From: [William Simcock](#)
To: [DCAdmin](#)
Subject: FW: 2020/622/91337/W - 1A Mount Pleasant Lane - Almondbury Ward
Date: 21 July 2020 09:27:00
Attachments: [1A two parking places.jpg](#)

From: Cllr Alison Munro
Sent: 13 July 2020 19:21
To: William Simcock <William.Simcock@kirklees.gov.uk>
Subject: 2020/622/91337/W - 1A Mount Pleasant Lane - Almondbury Ward

PROPOSED BLOCK PLAN
1:500

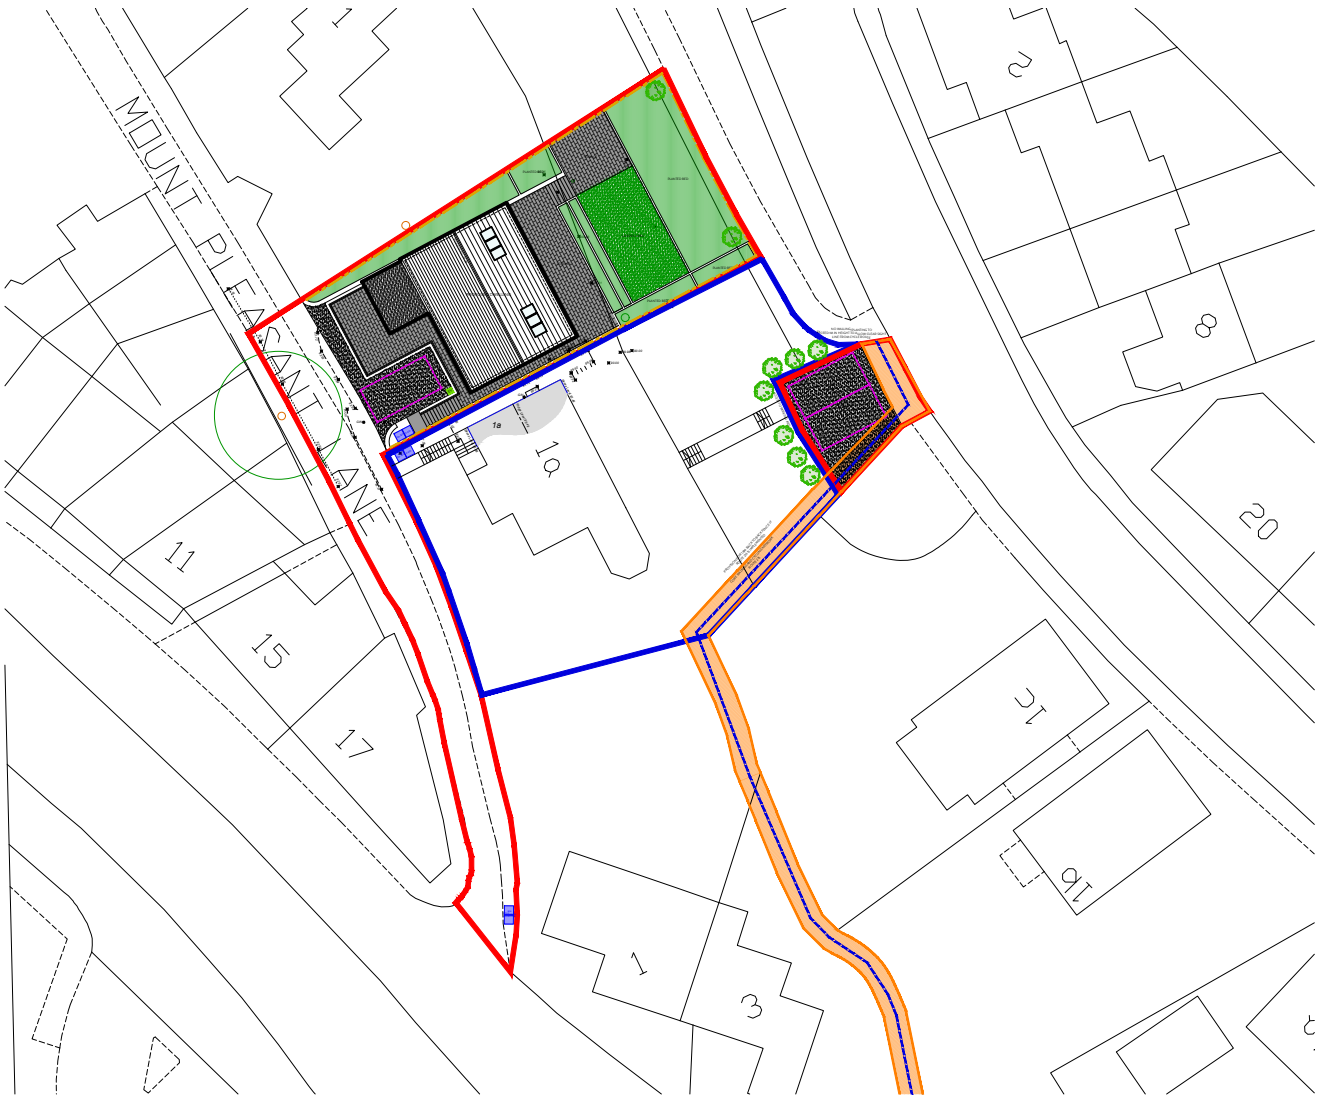
You will note from the plans that one parking place is shown at the front of the existing property on Mount Pleasant Lane and two at the rear of the existing property. The issue is this in that the two parking places shown on the plans at the rear of the property do not currently exist and it would be impossible to even get a car to the rear of the property as the property itself is about 3 meters up a steep banking with under garden parking at the front in the form of a double garage which easily allows for two cars to park there.

Additionally as there is no possible way for a car to access the rear of the property, a new access entrance will be required off Fenay Bridge Rd. On the planning application it says the owners are creating only one additional parking place and no new access will be required. Both these statements are I believe therefore false and I am not happy about this as I feel someone is trying to mislead both residents and officers.

The plans show only one property not two, so please can you clarify this as the shape of the house included in the plans does not resemble the current existing house.
